## OFFICIAL NOTICE OF DECISION

CITY OF ALBUQUERQUE  
PLANNING DEPARTMENT  
DEVELOPMENT REVIEW BOARD

**7. Project # 1002851**  
03DRB-01637 Major-Preliminary Plat Approval

ABQ ENGINEERING INC. agent(s) for INFILL SOLUTIONS request(s) the above action(s) for all or a portion of East ½ Tract(s) 4, ALVARADO GARDENS, (TO BE KNOWN AS **LA PLAZA ACEQUIA SUBDIVISION**) zoned R-2, located on CANDELARIA NW, between GLENWOOD RD NW and the DURANES LATERAL containing approximately 2 acre(s). (G-12)

# PLAT OF LA PLAZA ACEQUIA SUBDIVISION

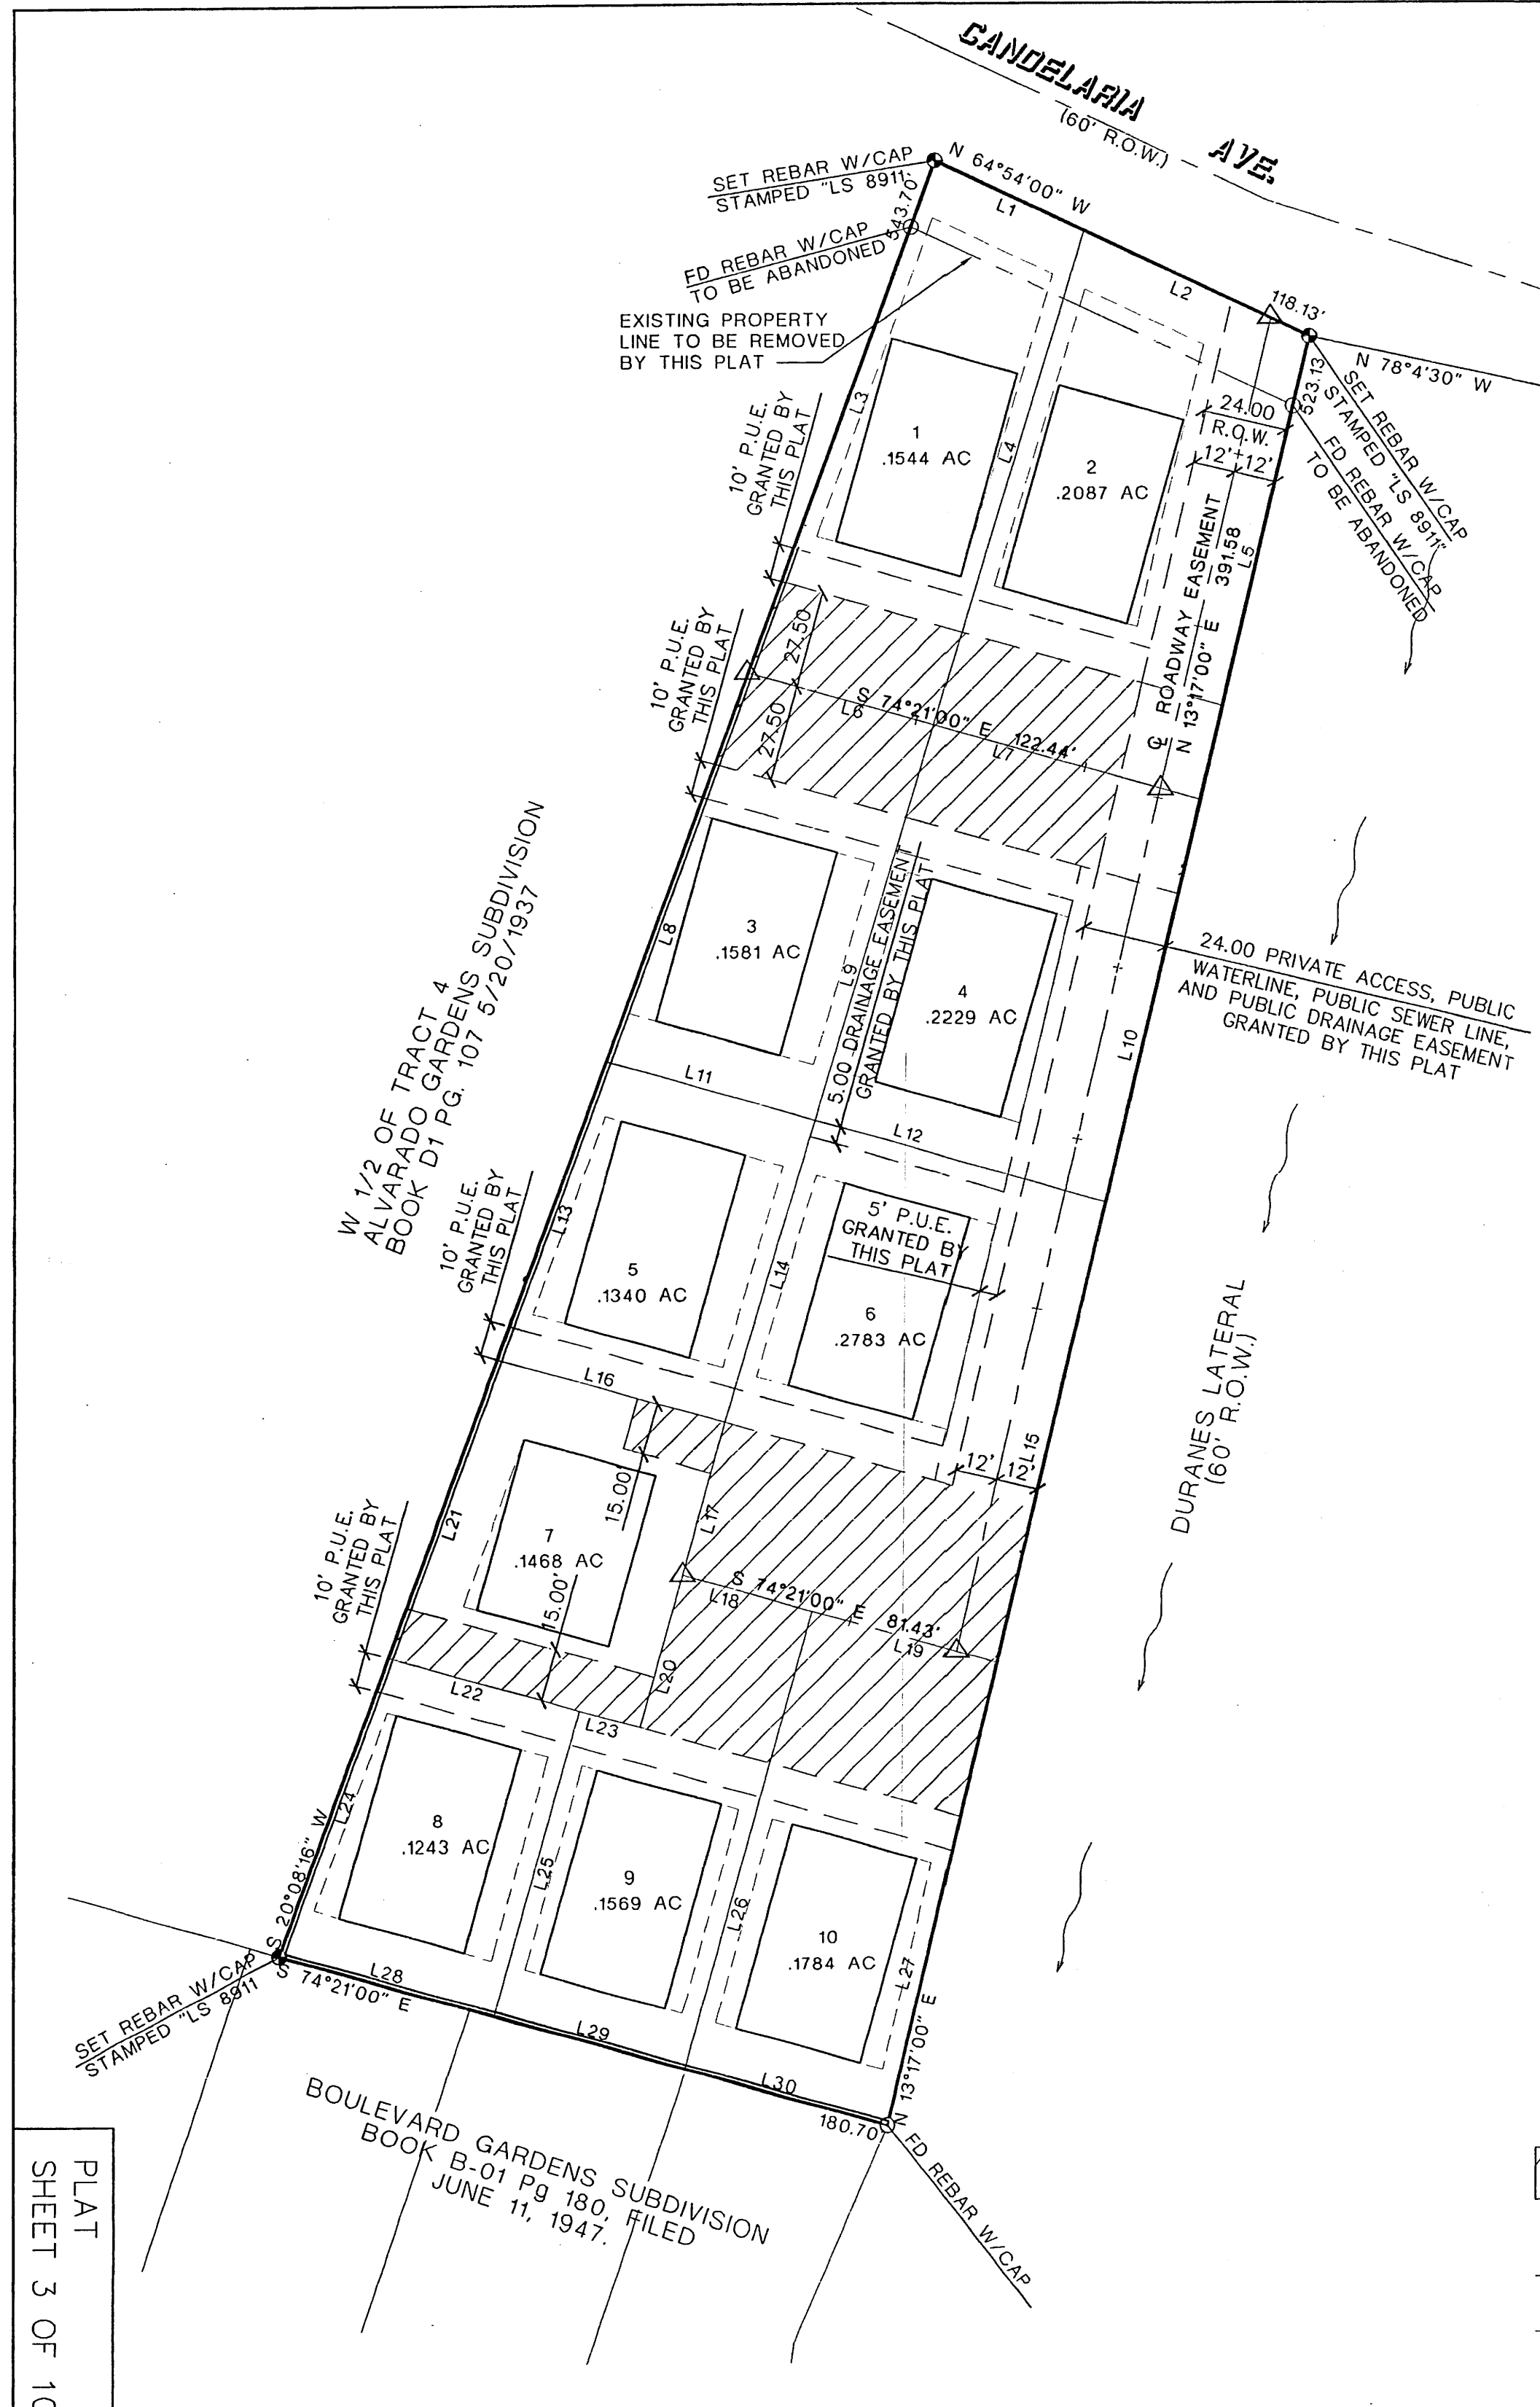
1. The easement along Candelaria, between Candelaria and the property, shall be identified. As a result, either a 24-foot driveway access easement across the unidentified easements must be shown on the final plat or the proposed unidentified easement must be vacated prior to final plat approval.
